From: Chantelle Bashford <Chantelle.Bashford@arun.gov.uk>
Sent: 02 February 2022 11:42
To: Planning.Responses <Planning.Responses@arun.gov.uk>
Subject: RE: Planning Consultation on: LU/411/21/PL

Application No: LU/411/21/PL
Registered: 7th January 2022
Site Address: 90-91 South Terrace Littlehampton BN17 5LJ
Grid Reference: 502860 101608
Description of Works: Change of use from existing leisure use to 10No. 1-bedroom 1 person supported living apartments, staff office, staff sleepover, and associated ancillary facilities to include extension to form new first floor, alterations to roof space including creation of dormer windows & installation of roof lights. This application is in CIL Zone 4 (zero rated) as flats.

project	Proposed Development 90-91 South Terrace Littlehampton, W Sussex
detail	Lower & Upper Ground Fire Strategy Plan
drawn	MAS
checked	
date	Dec 2021
status	Planning
a1 scale	a3 scale
1:100	1:200

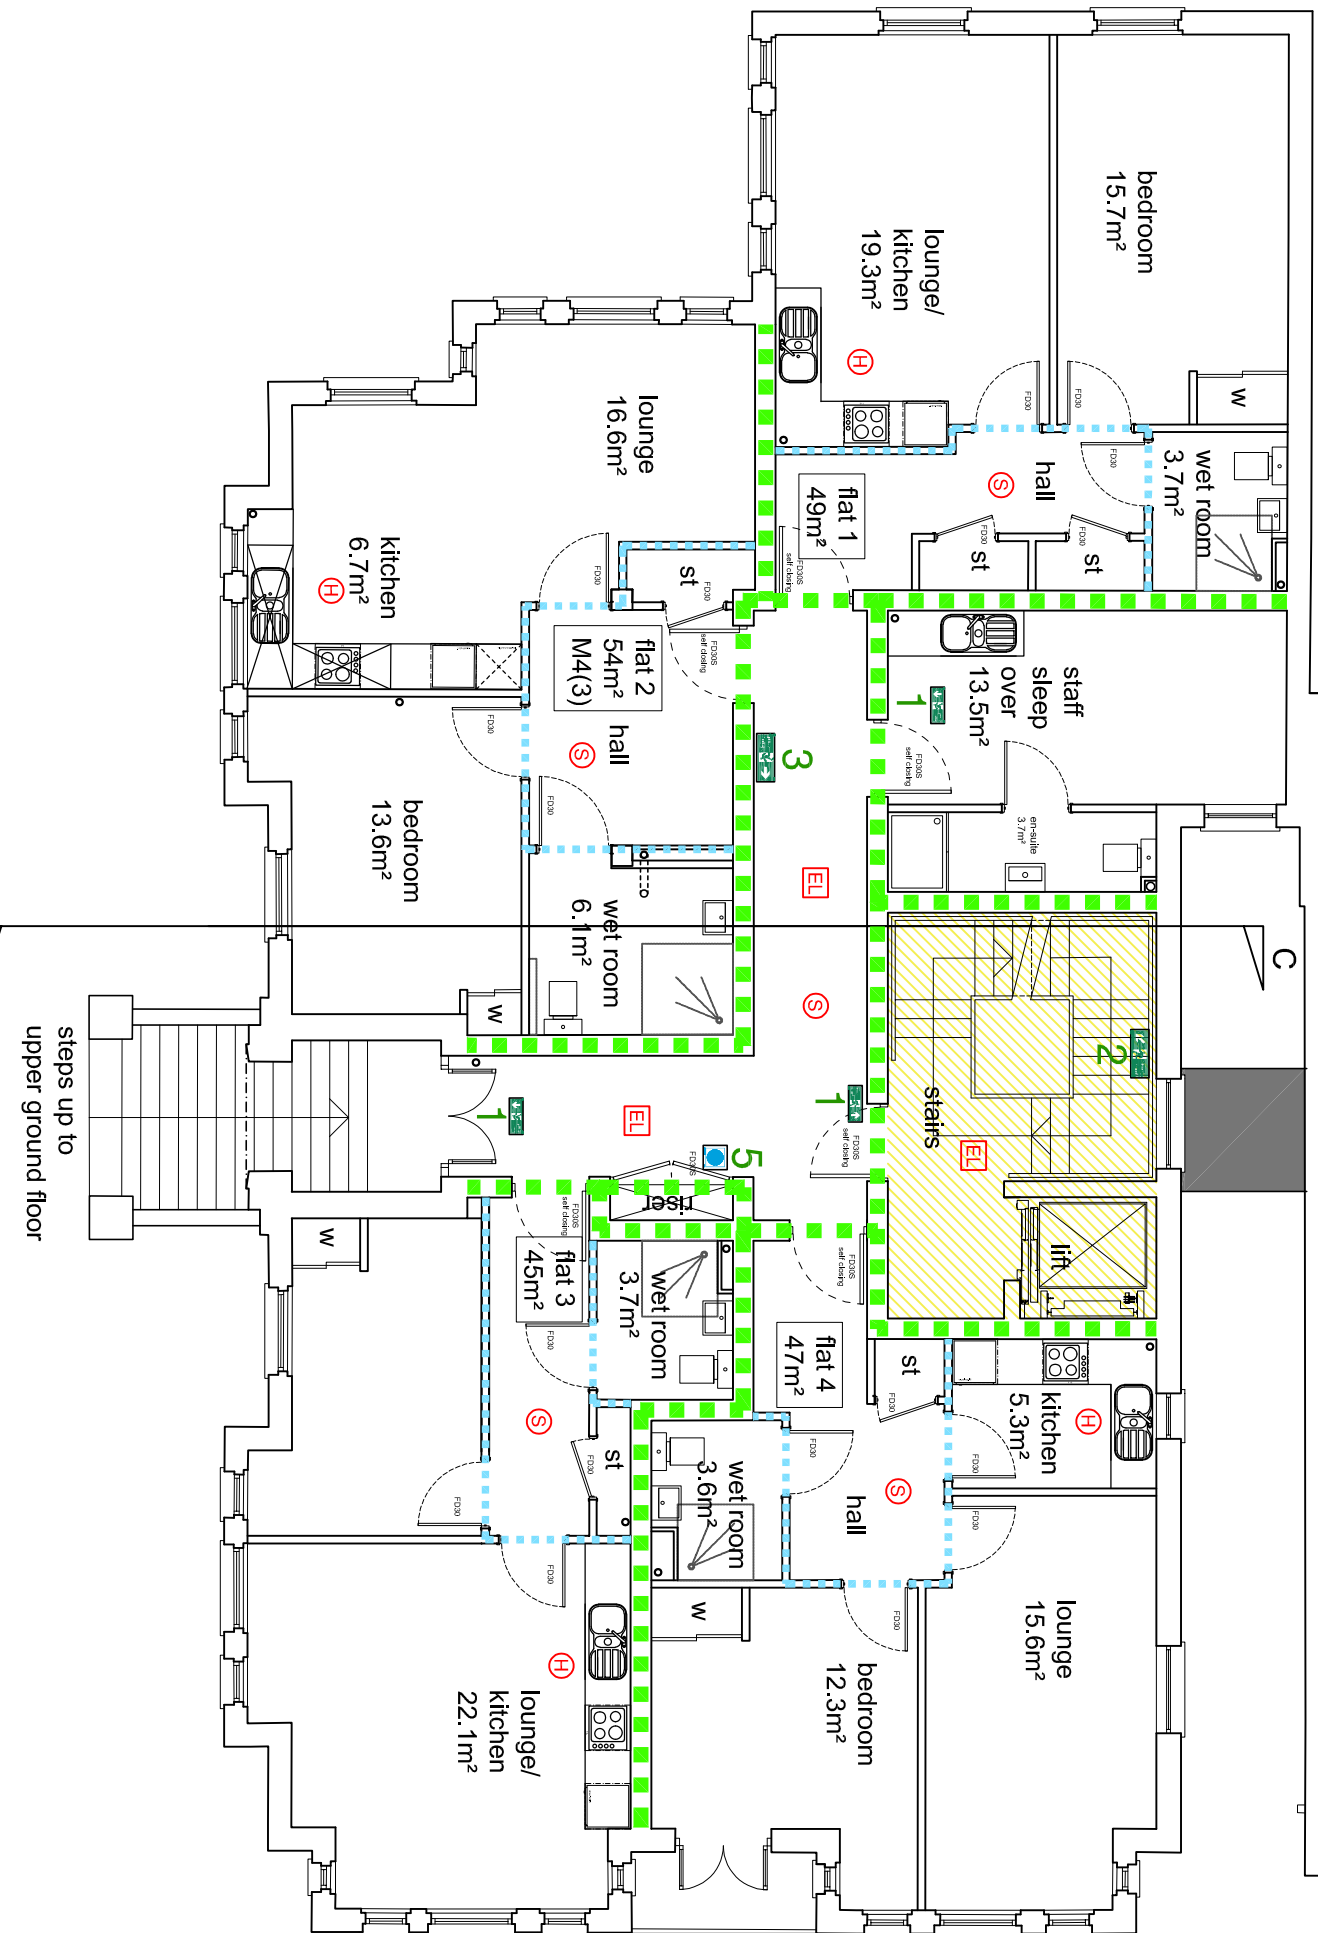
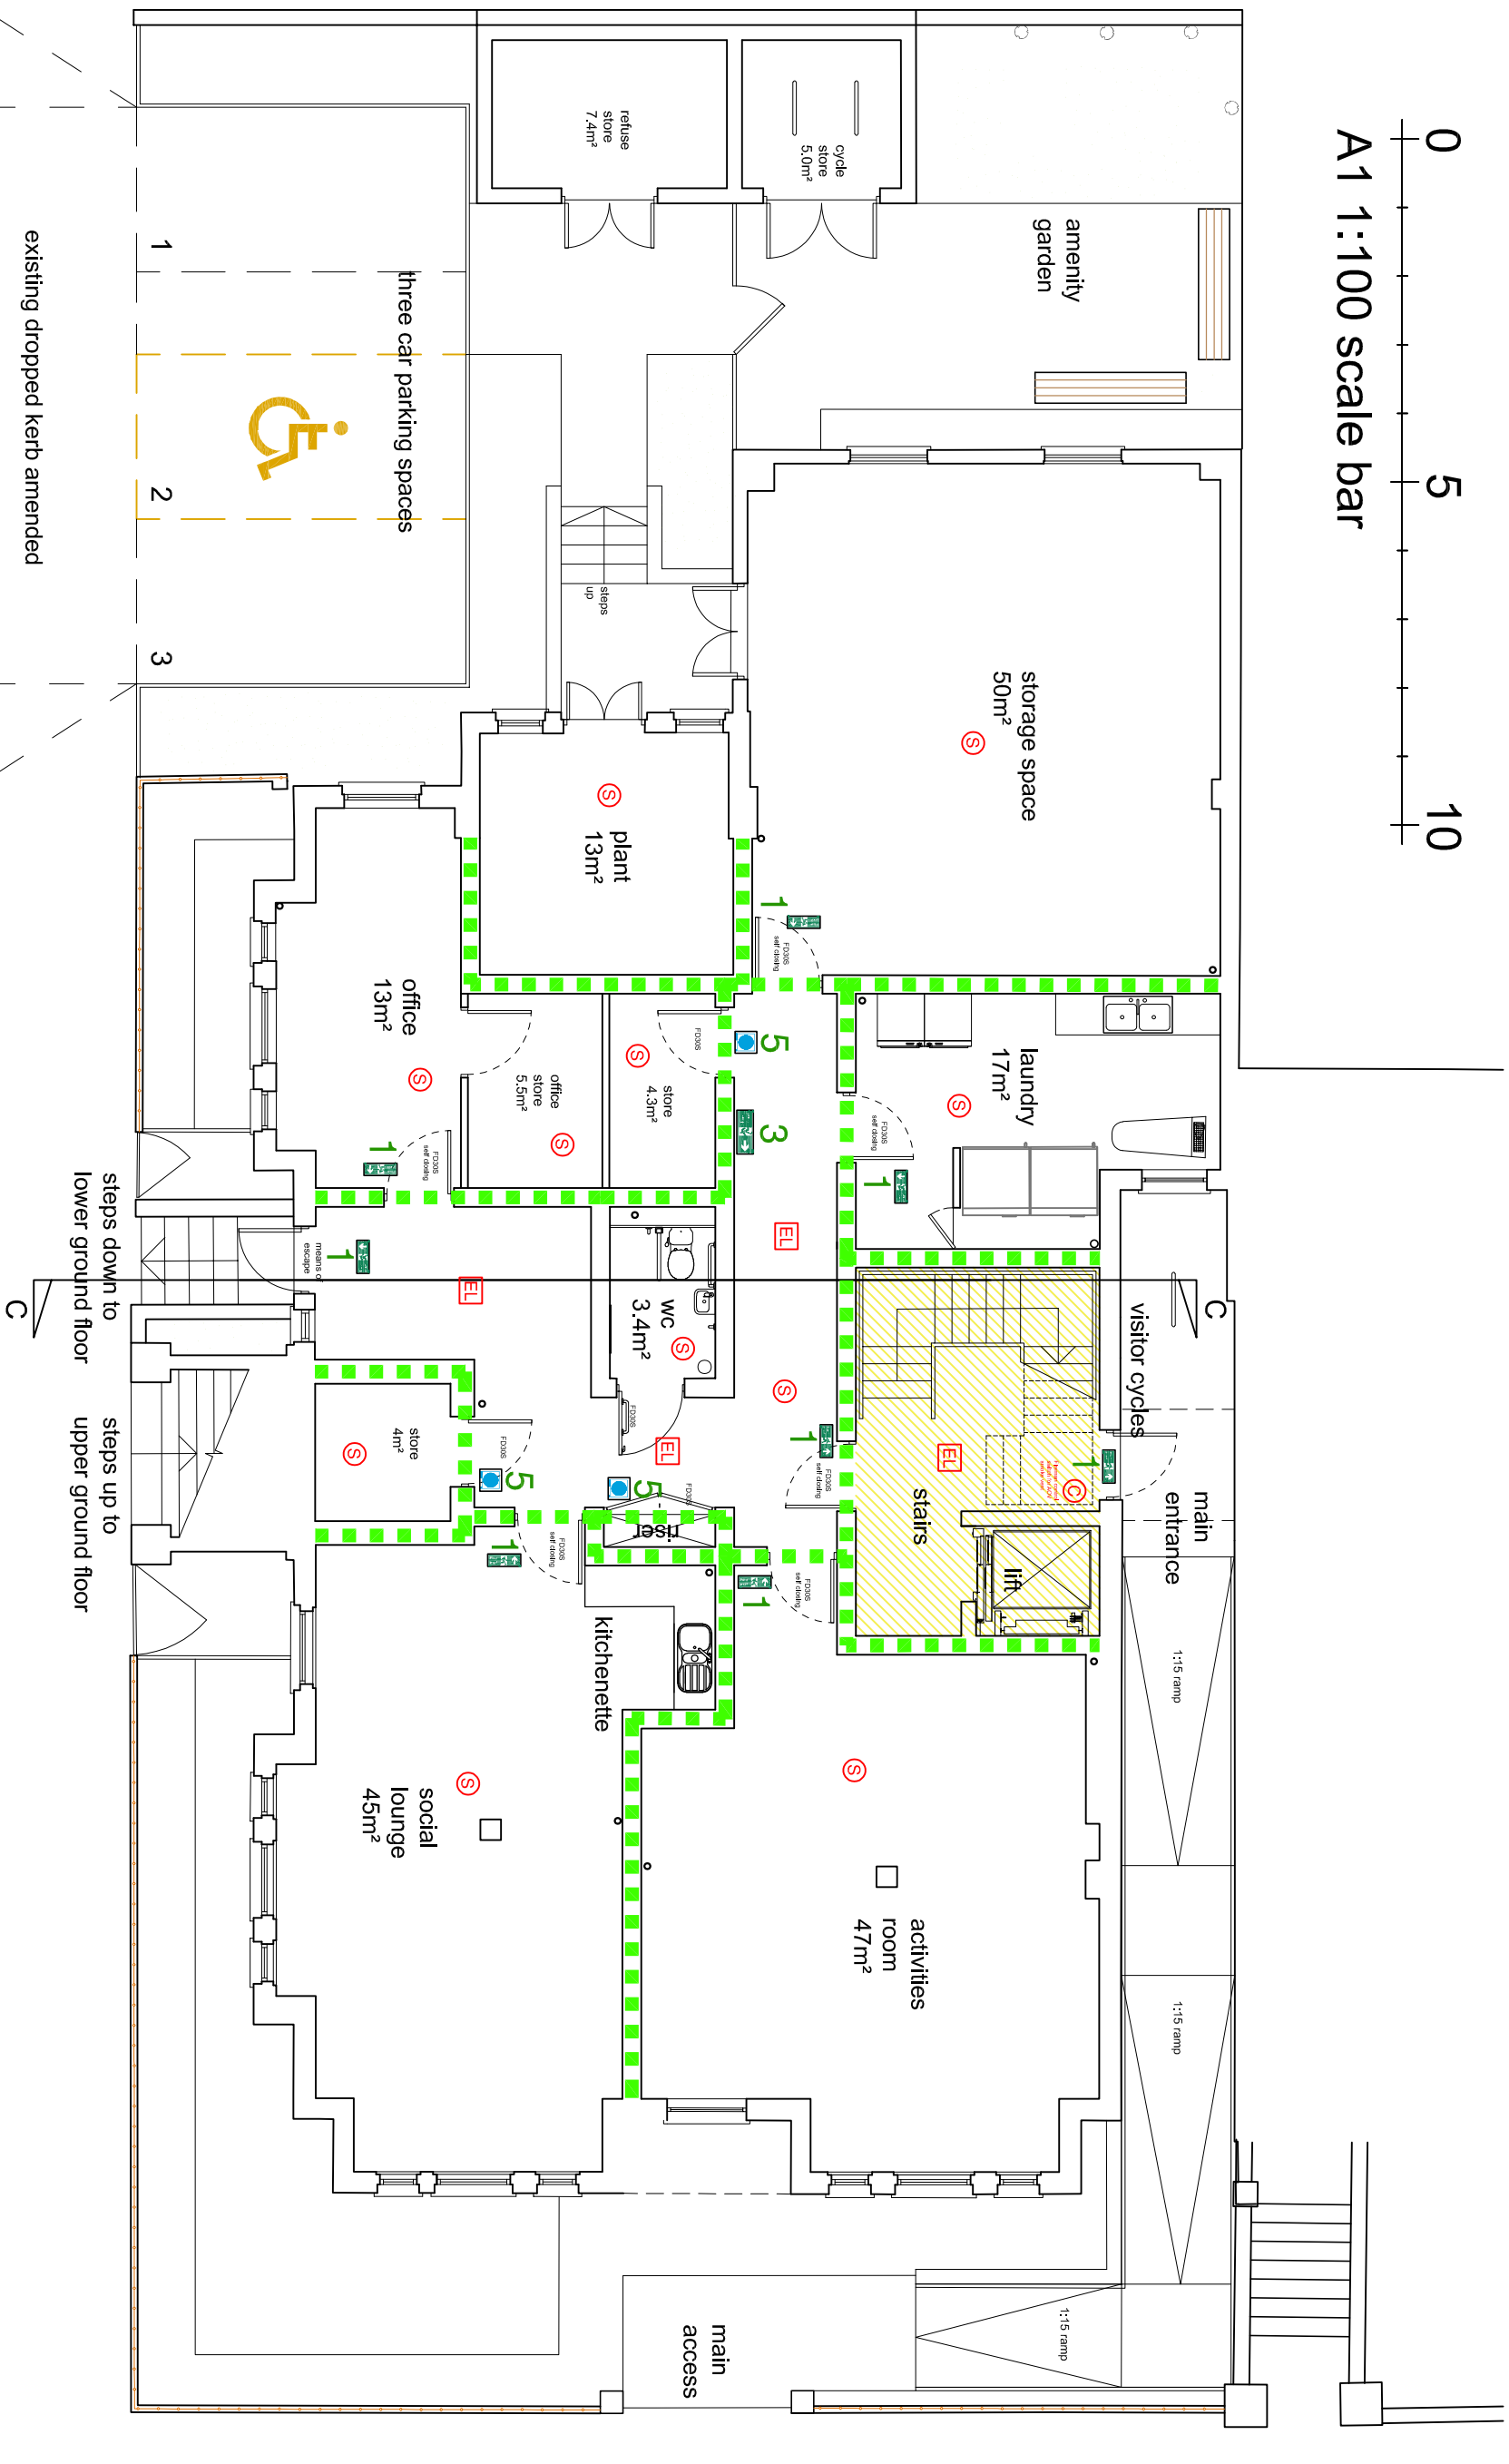
- Appropriate fire precaution facilities and equipment must be provided of such type, number and location as are considered necessary. Guidance on fire safety is contained in the LACORS guidance document – “Housing – Fire Safety, Guidance on fire safety precautions for certain types of existing housing”
- The Fire Strategy Plan specifies a Grade D1 LD2 fire system will be installed to flats 1-10, but does not make any reference to the common areas. However, it is assumed from the ‘Legend’ that the same fire system is being proposed to the common areas. If this is the case, a domestic fire system is not appropriate for this building and a mixed Grade A LD2, Grade D1 LD3 system is required.

Grade A LD2 system should be installed in the following areas:

- Throughout the escape route (smoke)
- Throughout the lower ground floor as all areas/rooms are for communal use (smoke, with the exception of the laundry room which may be more appropriate to have a heat detector)
- Within the 'Staff Sleepover' room on the upper ground floor (smoke – assuming no cooking facilities are being provided within this room, otherwise it would be more appropriate to install a heat detector and a stand-alone Grade D1 smoke alarm)
- Within each flat in the room/lobby opening onto the escape route (heat)

Grade D1 LD3 system should be installed in the following areas:

- Within each flat in the room/lobby opening onto the escape route (smoke)
 - If the kitchen areas within the flats are considered a higher risk and detection is to be installed to these areas also, these should comprise Grade D1 heat alarms and be interlinked with the Grade D1 smoke alarm within the flat
- Fire blankets should be provided to all kitchen areas

- Opening limiters should be installed to all windows above the ground floor to prevent windows being opened more than 100mm. Opening limiters should not be key operated. In this instance it would be appropriate to install opening limiters to the upper ground floor windows, also

- The balcony area to flat 4 must provide a guarding height of 1100mm minimum, extending up from the balcony floor
- The openings within the guarding should not allow a sphere with a 100mm diameter to pass through
- The guarding should not be constructed so as to facilitate climbing by children
